Application for a Non-Material Amendment Following a Grant of Planning Permission

Proposed conversion and extensions to the former care home to create four dwellings.

3/2018/0643

AMENDMENT TO THE BOUNDARY INFORMATION

AS BUILT SITE PLAN

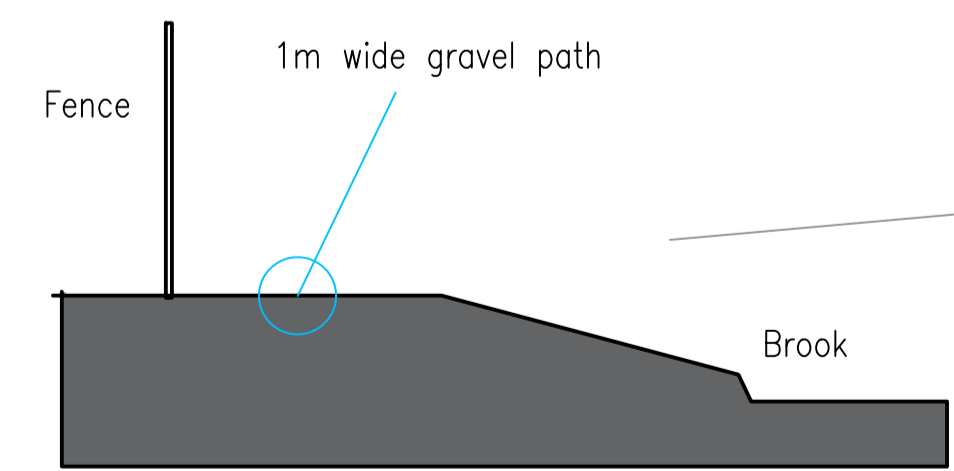
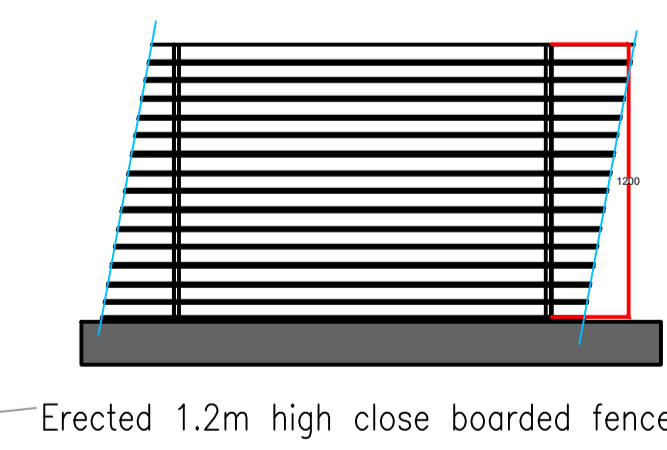
A NEW 1.2M HIGH CLOSE BOARDED FENCE AND MAINTENANCE PATH HAS BEEN ERECTED

I am in receipt of a complaint re the above and was hoping you could possibly assist with passing my details onto the applicant. The complaint relates to the boundary treatments which are not in accordance with the consent as boundary fencing has been installed at the property's boundary with the existing watercourse.

I have spoken to the developer who was instructed to carry out the works and a small access path has been created between the low boundary fencing and the watercourse for maintenance.

Having discussed the matter with the Head of Planning, it was advised that a NMA application be submitted to address the issue. Link to Condition attached which states that the garden boundaries will remain open to the watercourse.
